Council Reference: D26/330331
Contact Person: David Zabell

Air Liquide CO2 Processing Plant – SSD-80824235
340 Bolong Road Bomaderry

I refer to the Department of Planning, Housing, and Infrastructure's request for comment in relation to Manildra MOD-26.

Figure 3. Detention pond

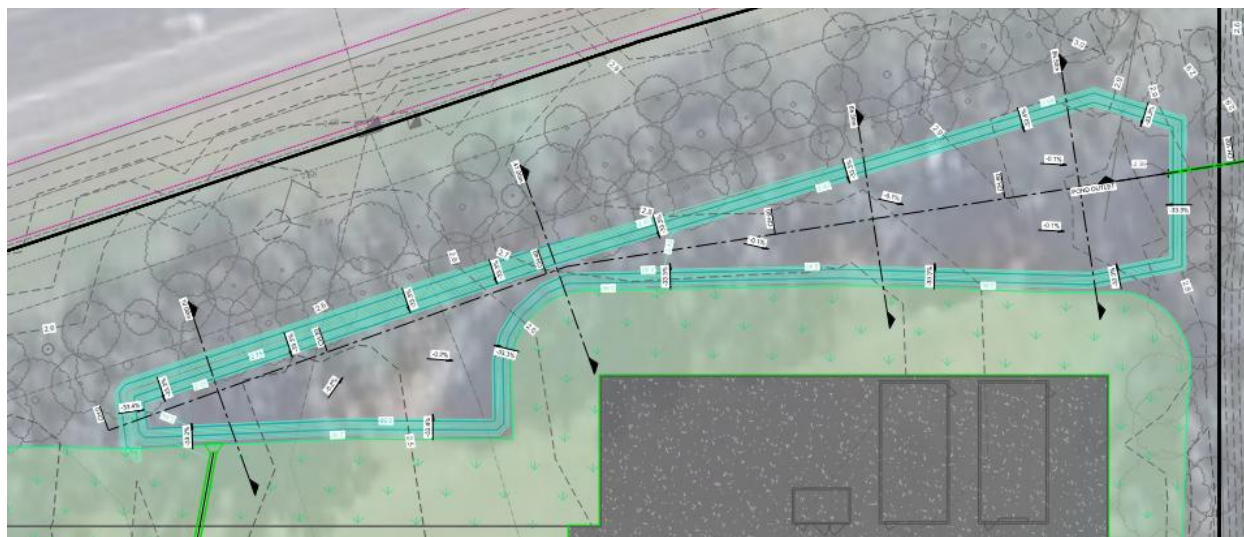
It is noted that the rational formula was used to estimate OSD requirements. This method is no longer supported by Australian Rainfall and Runoff 2019. However, it is noted that the Development Engineer has conditioned the use of DRAINS modelling (or equivalent) during CC stage to demonstrate that the stormwater system, including the detention basin, is appropriately sized in accordance with current best practice. This is acceptable.

DRAWING TITLE:
STORMWATER LAYOUT PLAN

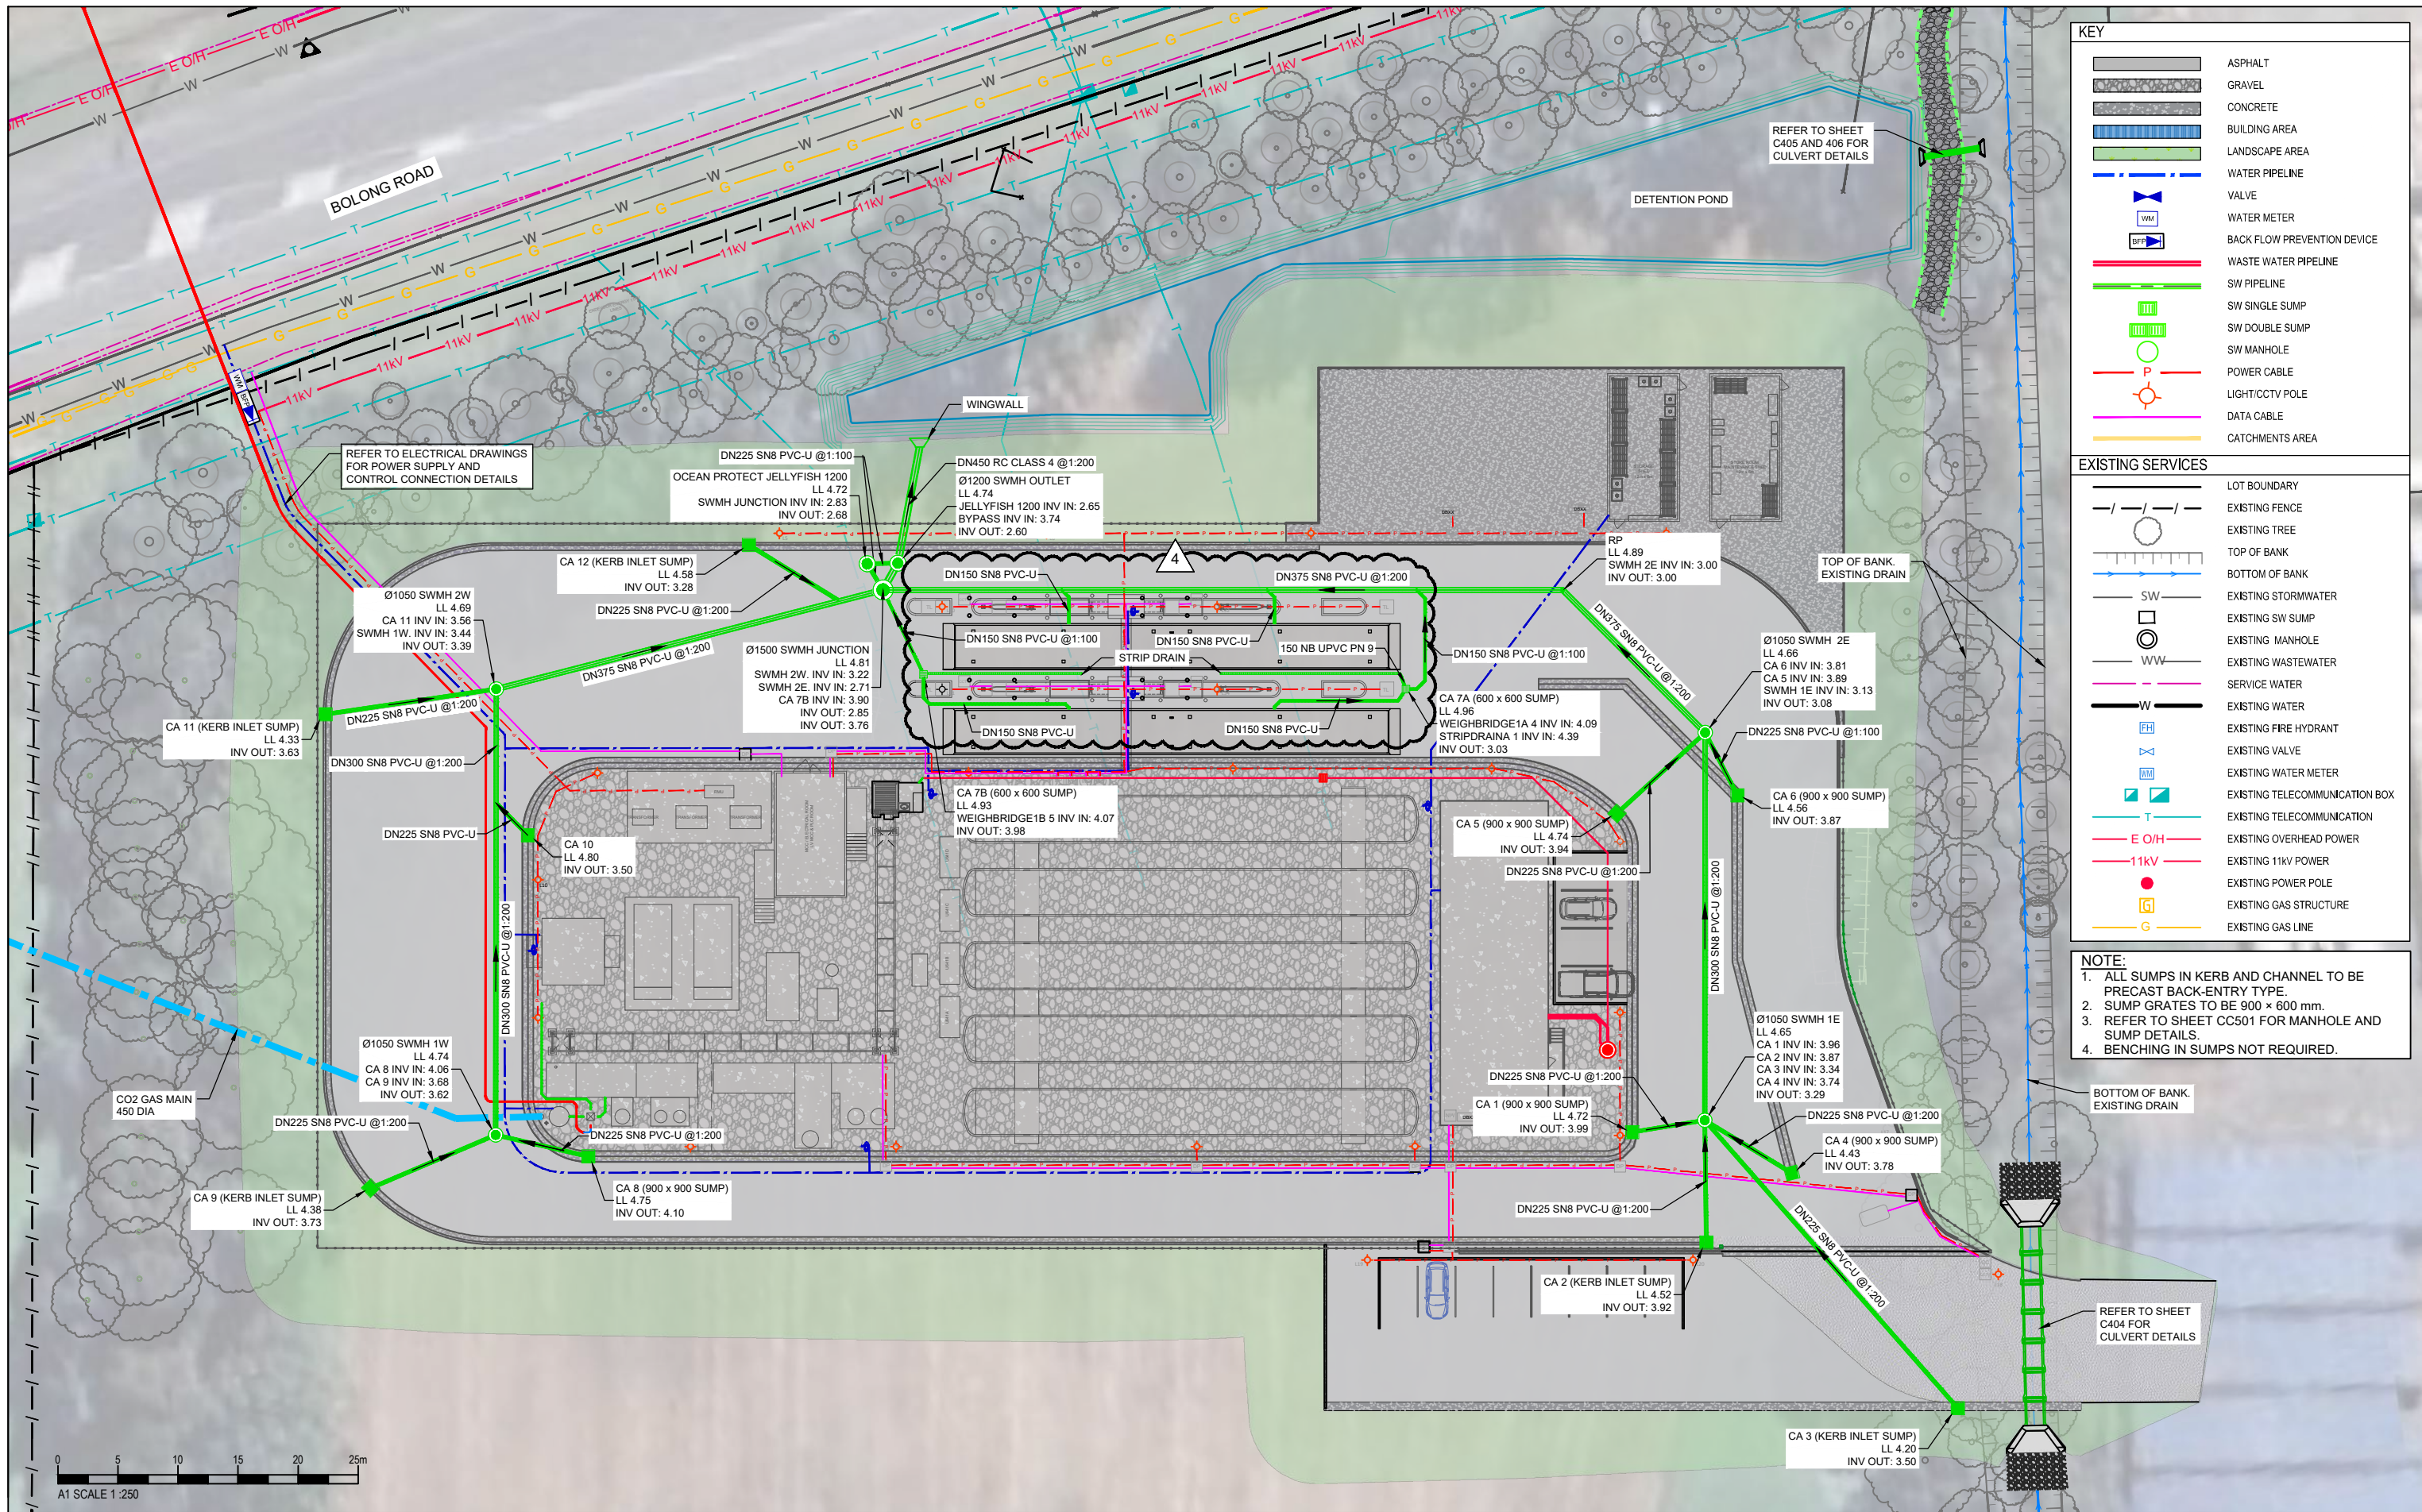
A Stormwater Management Plan, prepared by Babbage, has been submitted by the applicant. The plan outlines a proposed treatment strategy consisting of Ocean Guard units in sumps and a Jellyfish treatment device (JF-1200-2-1 WSUD) located immediately upstream of the detention pond. MUSIC modelling was completed to verify that the proposed treatment devices could successfully reduce contaminants to the required levels. It will be conditioned that the MUSIC model is provided to Council for review prior to CC.

Table 5 of the Stormwater Management Plan indicates that the key pollution reduction targets can be achieved. It is unclear what treatment capacity of these assets has been used in the modelling.

Site Plan

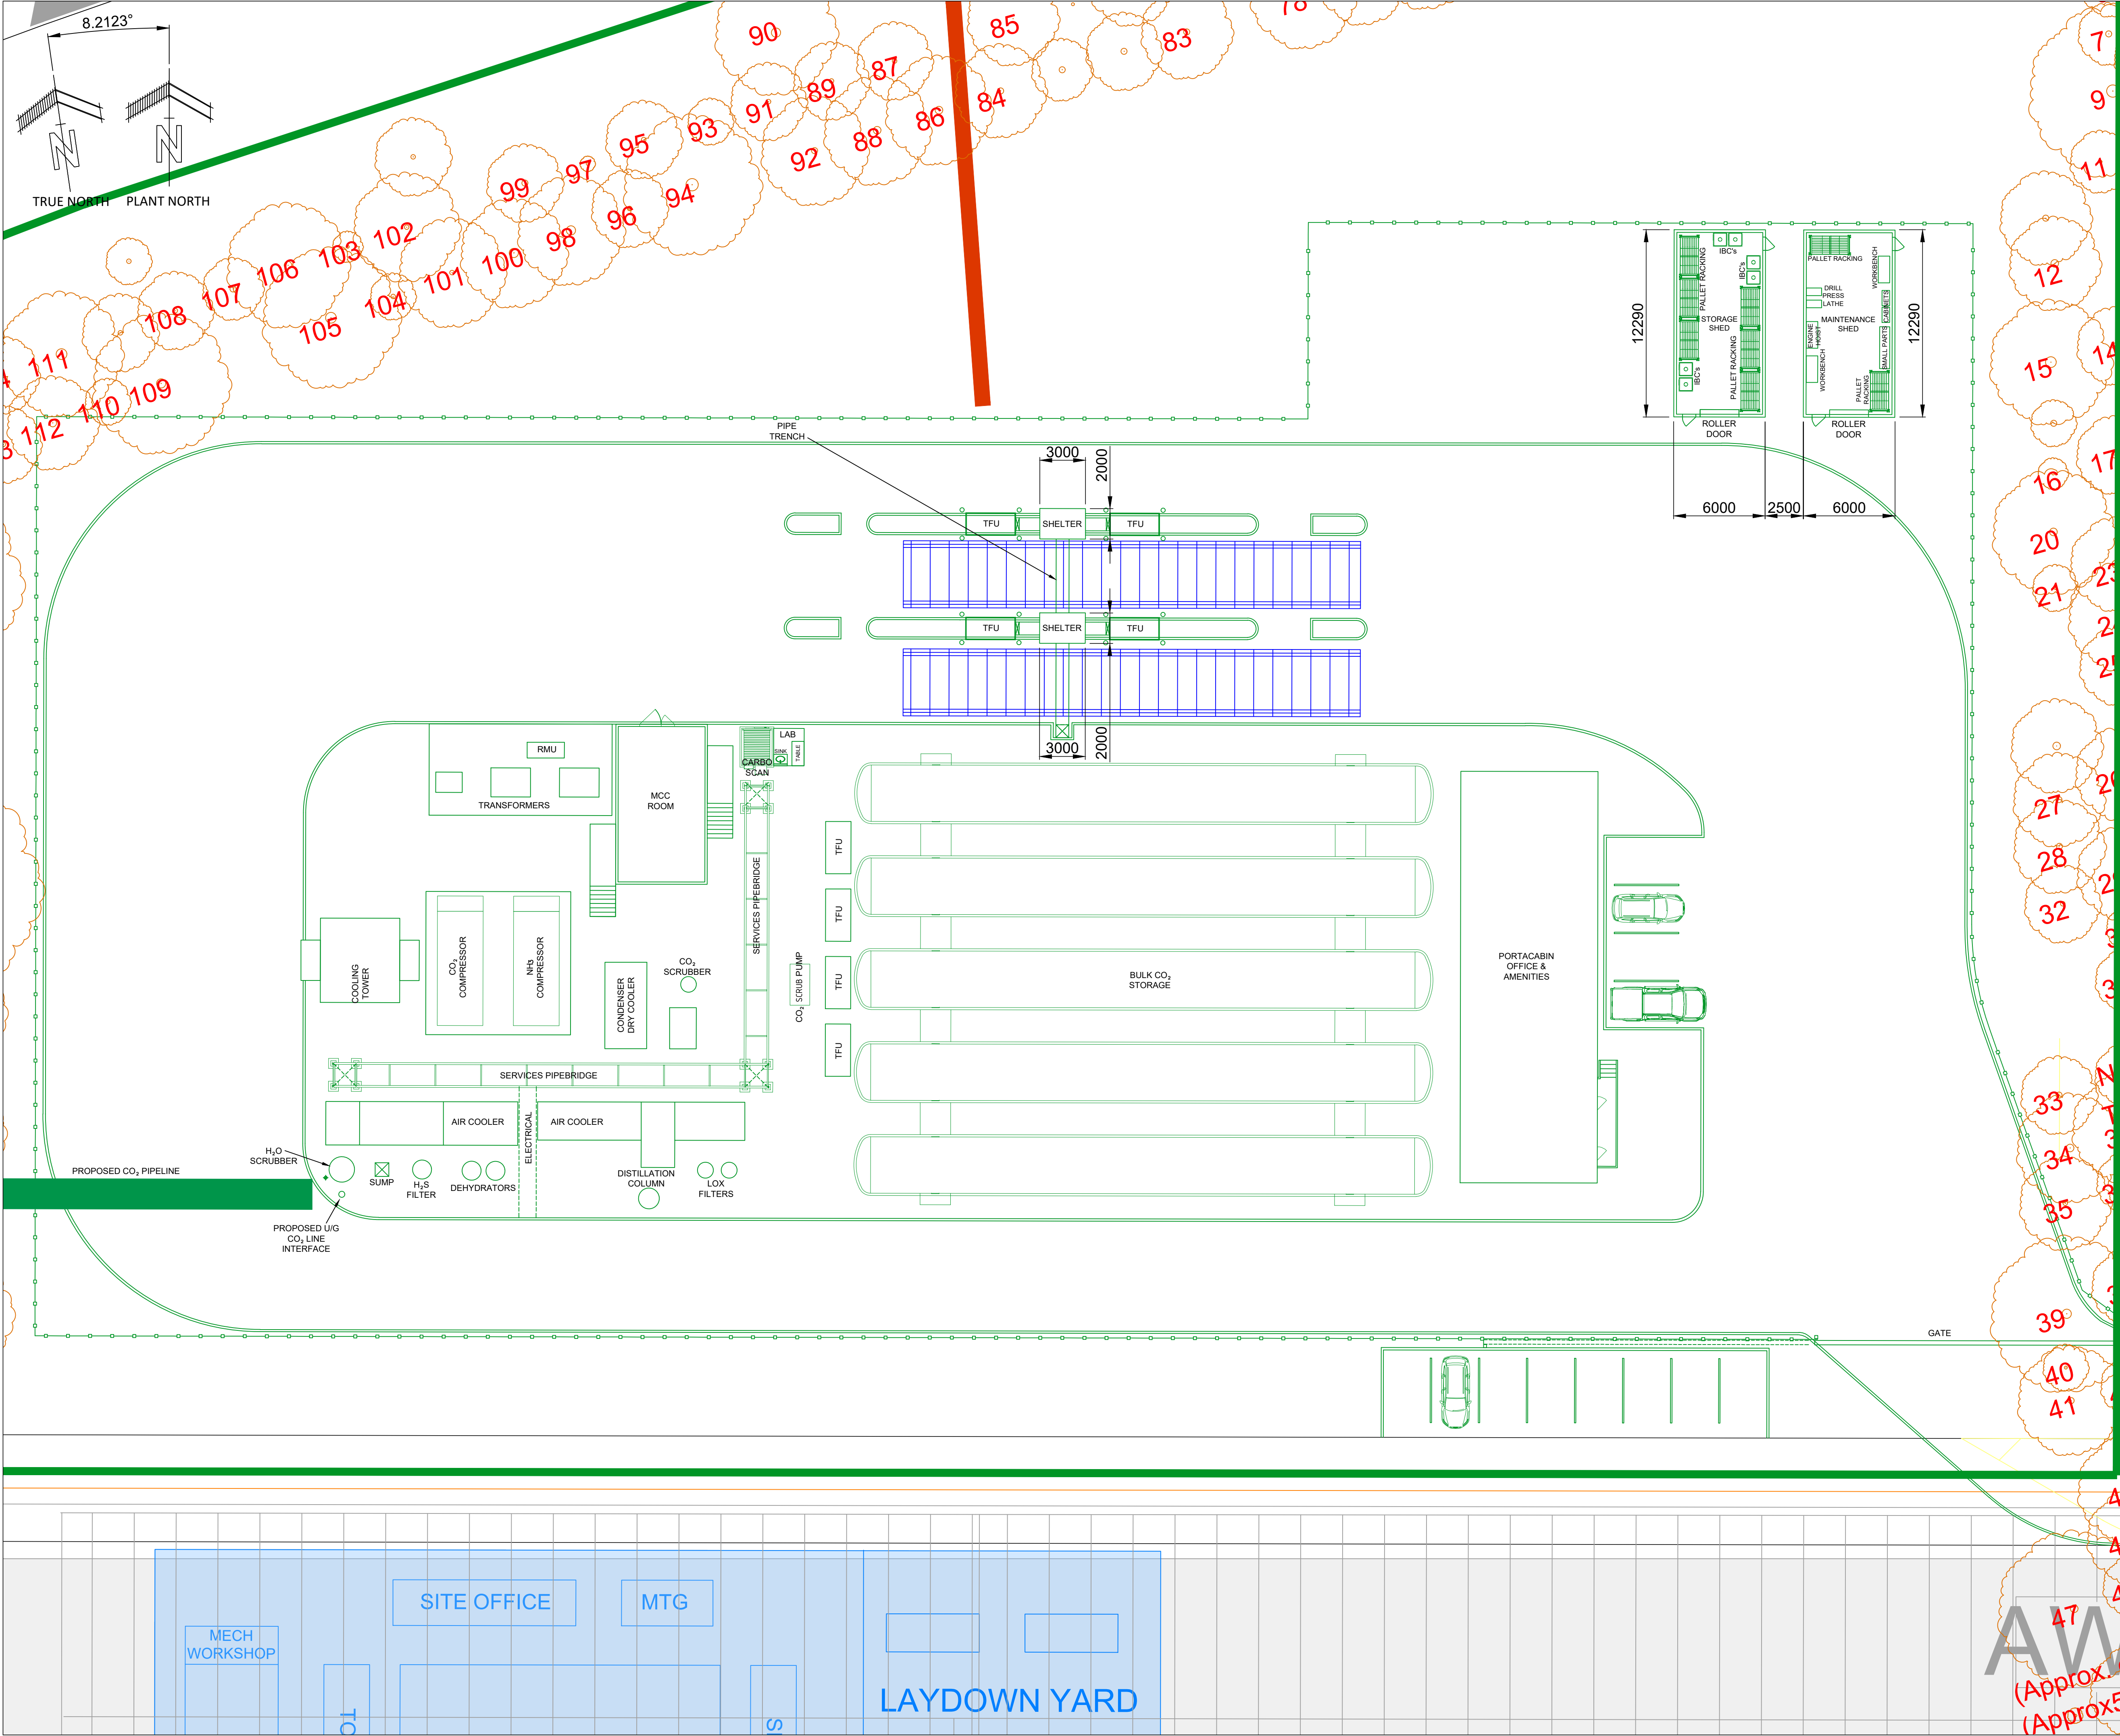
The proposed development does include several buildings, and a CC will be required. The submitted site plans do not contain any details of the proposed use of the buildings, or floor plans, elevations etc. It appears from the 3D Views (e.g. A42) that there is a building that could contain offices/ administration (Class 5) adjoining several parking spaces.

The BCA and Disability (Access to Premises – Buildings) Standards require access for people with a disability to and within all areas of the building normally used by the occupants. The principal pedestrian entry to the assumed office/ administration building is via stairs/ landing which will not comply. If the floor level of the building cannot be lowered, then a series of ramps would need to be constructed in the proposed grassed area on the landscape plan (snip below). This would reduce the proposed soft/ pervious area of the development. If the potential reduction in the turfed area does not raise any planning concerns, this can be addressed at CC.

In addition, an accessible car parking space will be required which has not been shown on any of the plans. Any accessible parking space should be located amongst the spaces immediately adjoining the assumed office building. The provision of an accessible parking space complying with AS2890.6 will require a shared area adjoining the space. The provision of an accessible car space in the existing arrangement will reduce the total number of proposed parking spaces by one. If a potentially reduced number of car parking spaces does not raise any planning concerns, it can be addressed at CC.

The use of the two buildings located between the processing plant and Bolong Road is unknown, as is the distance/ setback between the two buildings. If the separation between the buildings is less than 3 metres, the external walls may require a Fire Resistance Level (FRL) to comply with the BCA.

The plans that have accompanied the application do not appear to have met the minimum level of information for submission. It is recommended that the consent authority request amended/ additional plans that shows the use of the buildings.
